An
Bord
Pleanála

Inspector's Report ABP 305804-19

Whether construction of agricultural shed and extension of access lane is or is not development or is or is not exempted development.

Liosúl Cottage, Gigginstown, Mullingar, Co. Westmeath.

**PROPOSED AGRICULTURAL SHED**  
**SHED PLANS AND ELEVATIONS**

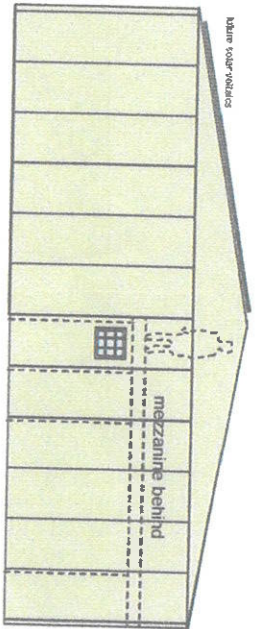
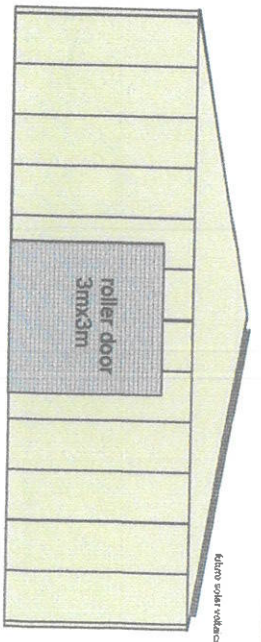
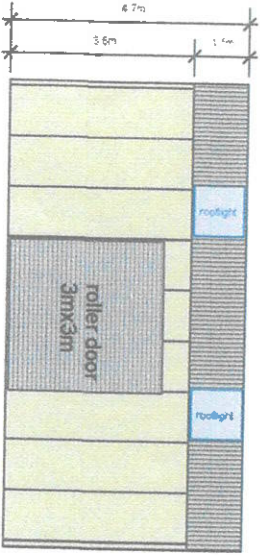
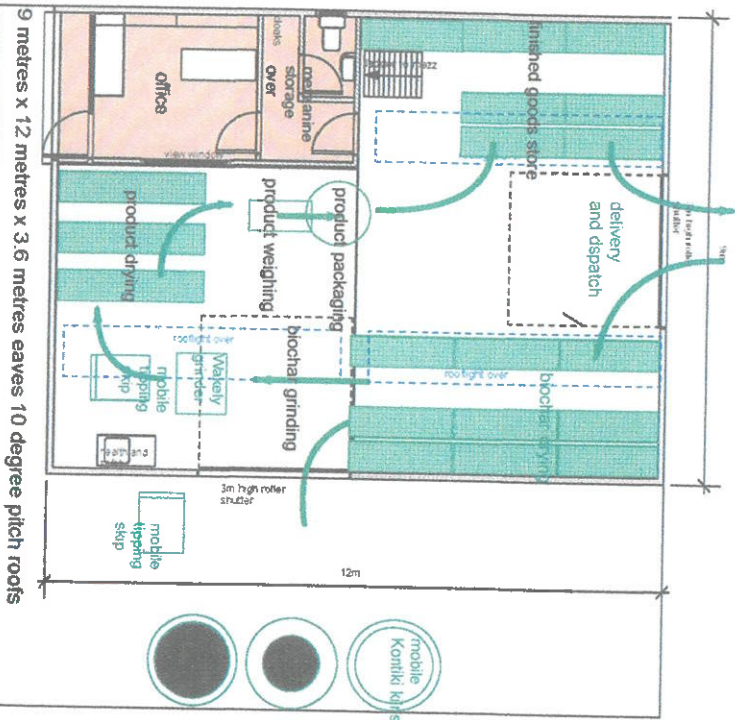
The floor area of the proposed shed is 108 sq.m. at ground level and c. 21. sq.m at mezzanine floor level, providing a combined total gross floor area of c.129 sq.m. The Site Layout Plan submitted shows that there is a polytunnel located on the landholding which has a measured gross floor area of c.140 sq.m. As the gross floor area of the proposed shed together with the polytunnel do not exceed 900 sq.m. in aggregate, the proposal complies with Condition No. 2.

- 8.5.2. Having regard to the ridge height of the proposed shed at 4.7m, its location to the rear of the existing cottage and the dense trees and hedgerows along the side and rear boundaries of the site, I consider that the proposal would not be highly visible in the surrounding rural landscape. There is no scenic view or vista identified in the Development Plan in relation to this site. As such the proposed shed is not de-exempted by the provisions in Article 9 of the Regulations.
- 8.5.3. Notwithstanding the above, I conclude that the proposed shed would not be agricultural in use and thereby does not comply with the terms of Condition No. 1 of Class 9 of Schedule 2, Part 3 of the Planning and Development Regulations 2001 (as amended). The proposed shed would, therefore, not be exempted development.

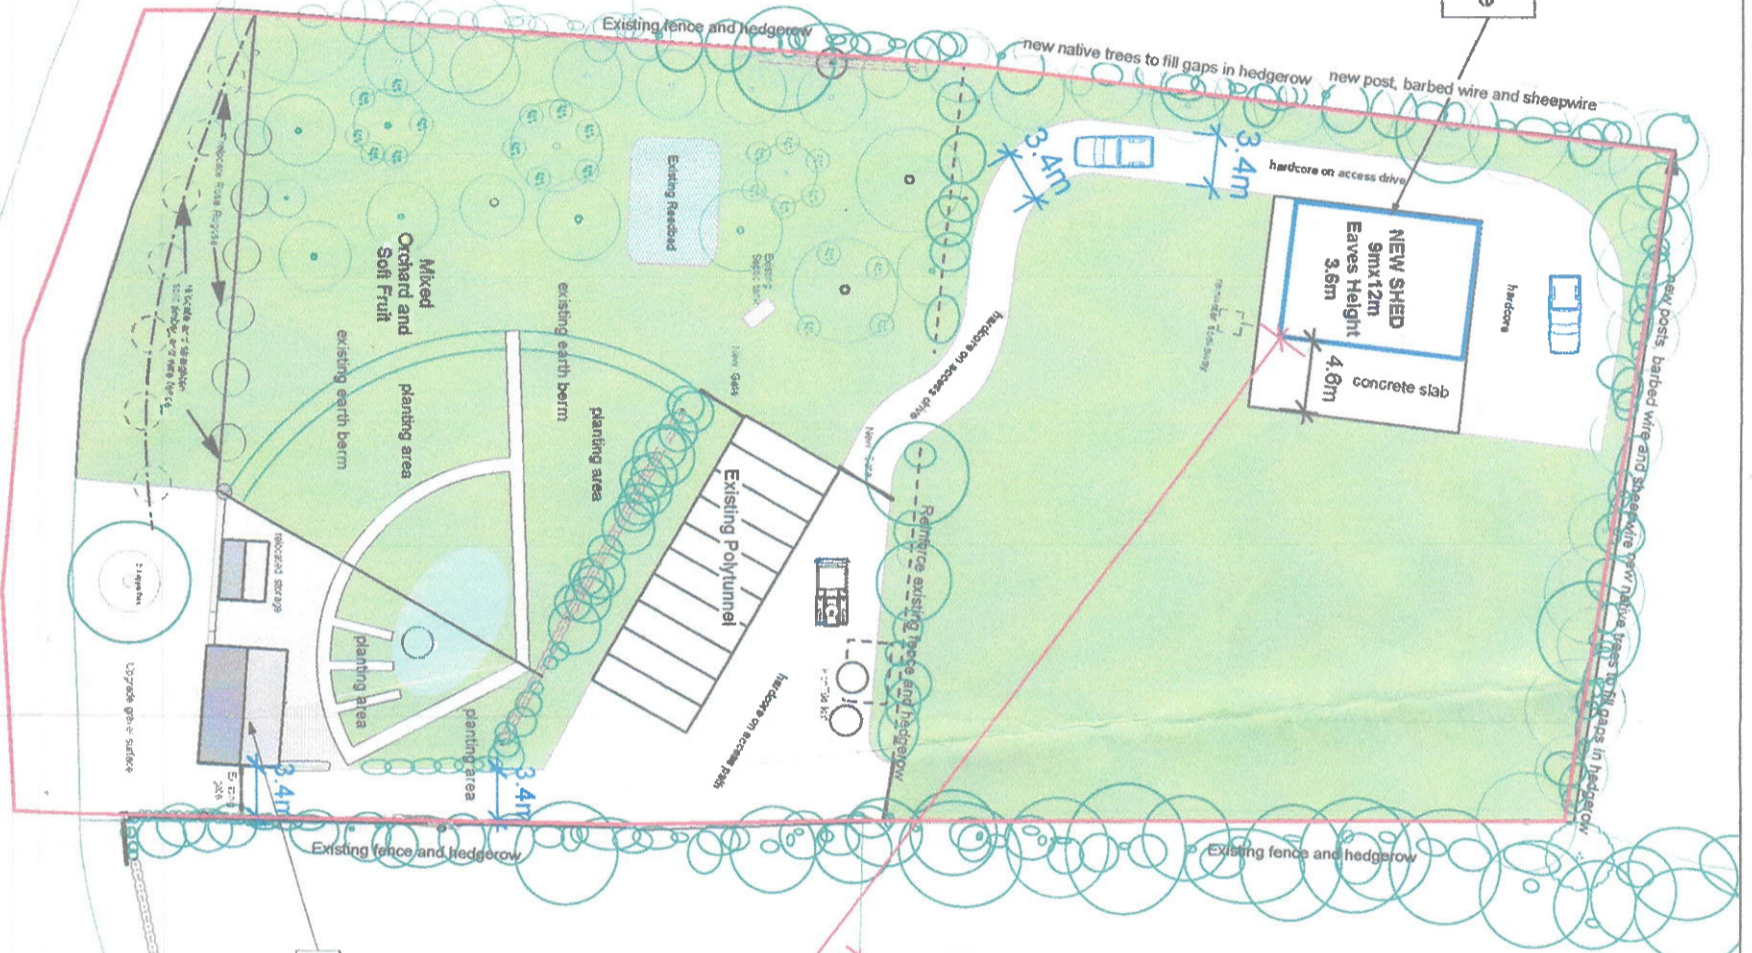
The Site Layout Plan details that the proposed structure would be located 101 metres from the nearest dwelling, located on adjoining lands to the north-west. As such the proposal would comply with this Condition.

The applicant details that the proposed yards would be used for the production and delivery of biochar. The Site Layout Plan submitted details that 2 no. kilns used for the production of the biochar would be located on the yard to the rear / south of the polytunnel. The applicant states feedstock will be pyrolysed in 3 mobile open-air kilns on-site. As detailed above, it is my view that the thermo-chemical process and activity involved in its production of biochar is not agricultural. As such, I consider that the proposed yards would not be used for the purposes of agriculture, and therefore do not comply with the terms of Condition No. 1.

Having regard to the Site Layout Plan, I calculate that the gross floor area of the yard to the rear / south of the proposed shed is c.90 sq.m., the concrete slab is 46 sq.m. and the yard to the south of the polytunnel (excluding the access lane) is c.120 sq.m. This provides a cumulative total of 256 sq.m. The proposed yards therefore comply with this Condition.

The yard to the rear / south of the proposed shed would be located c.105m from the closest dwelling located to the north-west. The concrete slab located to the western side of the proposed shed would be located in excess of 100m for the most part from the closest neighbouring dwelling. The infringement is minimal. As such it is my view that the proposed yard to the side and rear of the proposed shed complies with the terms of Condition No. 6.

The proposed yard to the south of the existing polytunnel would be located 55 metres at its closest point from the neighbouring dwelling, located on adjoining lands to the north-east. The Site Layout Plan details that 2 no. kilns used for the production of the biochar would be located on this yard. The applicant has not submitted written consent from the owner/occupier of the said neighbouring dwelling. As such this yard, by reason of its proximity to the neighbouring dwelling, does not comply with the terms of Condition No. 6.

8.7.2. The applicant proposes to extend the existing lane to the side of the house with a 3.4m wide lane, extending for a length of c. 105 metres to join the proposed shed. As such the width of the proposed access lane is not de-exempted by the provisions in Article 9 (1)(a)(ii) of the Regulations.
